Qantas Flight Training Centre (SSD 10154) - Notice of Exhibition

Thank you for your letter, requesting Transport for NSW (TfNSW) review and comment on the above.

Existing redistributed
weekday morning traffic flows
plus development traffic

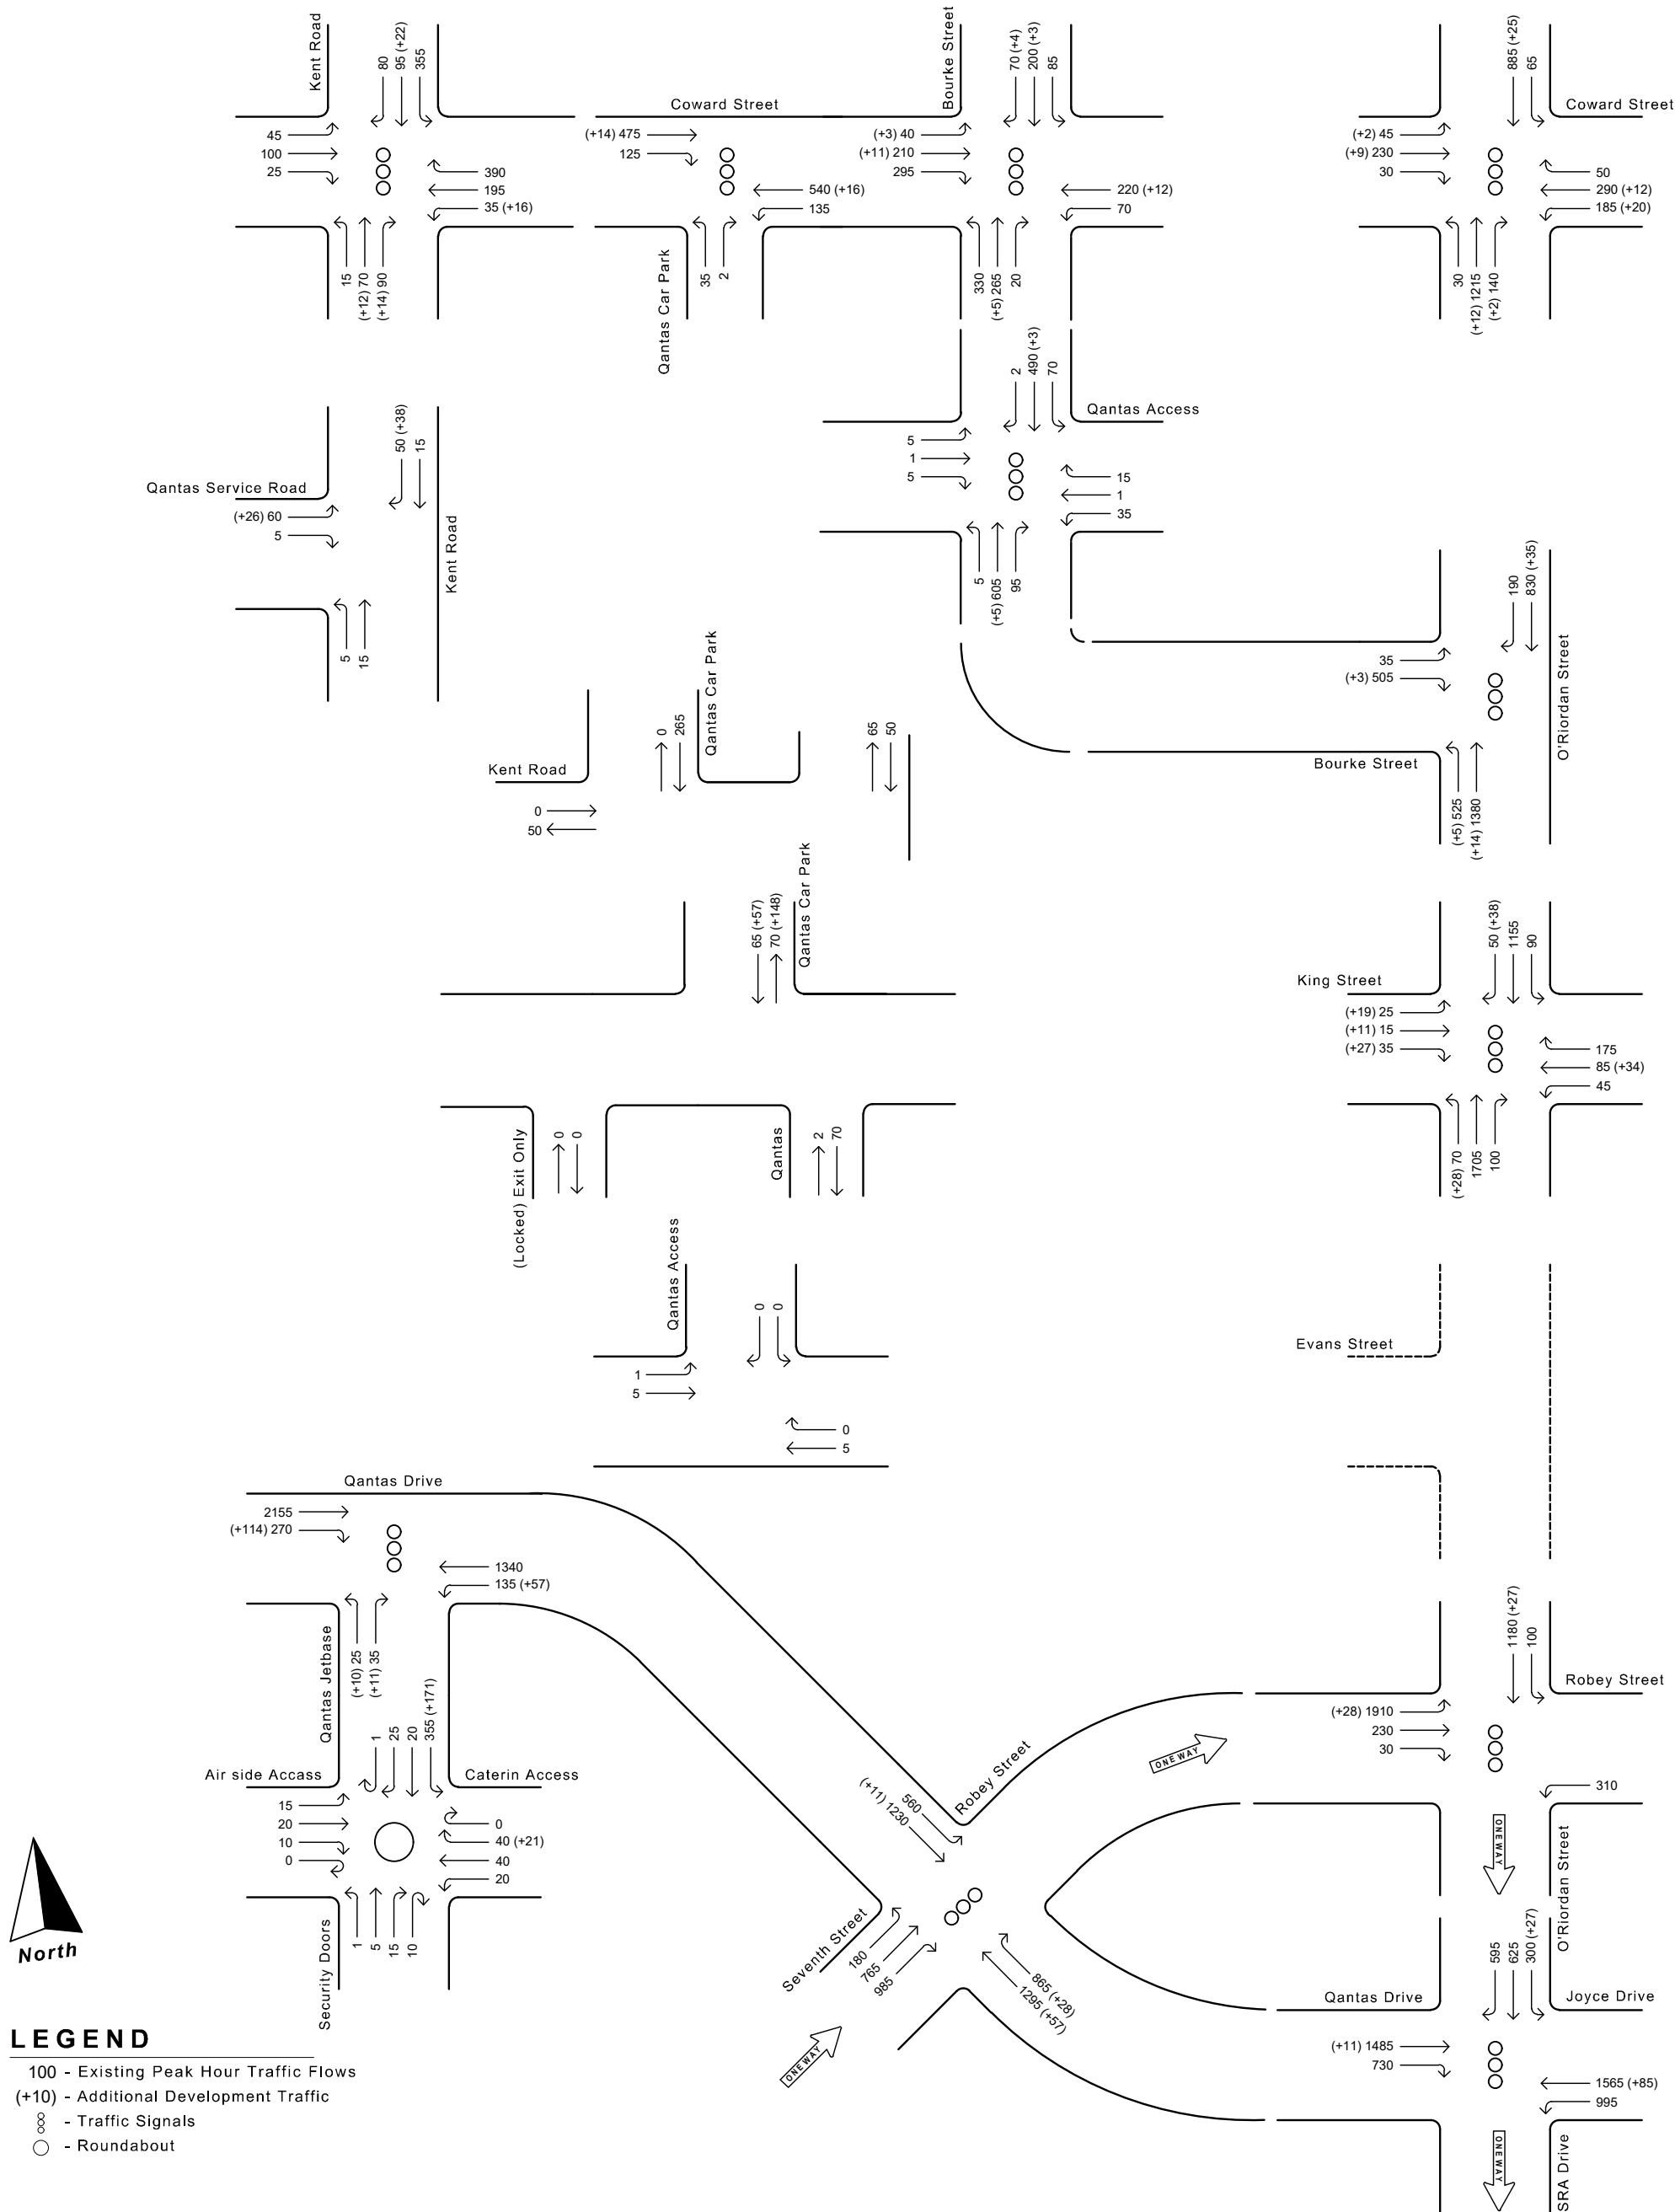
- The trip distribution in the Traffic Report indicates an existing volume of 50 vehicles turning right from King Street (morning peak) onto O’Riordan Street, however no right turn movement is currently permitted;

It is requested that the applicant provides updated traffic report with the following information as part of the applicant’s Response to Submissions:

- Electronic SIDRA files for the existing and future scenarios;
- Detailed SIDRA outputs for the Qantas Drive/Qantas Jetbase access and O’Riordan Street/King Street intersections; and
- Detailed queueing assessment to justify that the number of proposed boom gates are adequate to minimise queuing from the site to the classified road network and not impact the safety and efficiency of the classified road network in particular Qantas Drive and O’Riordan Street.
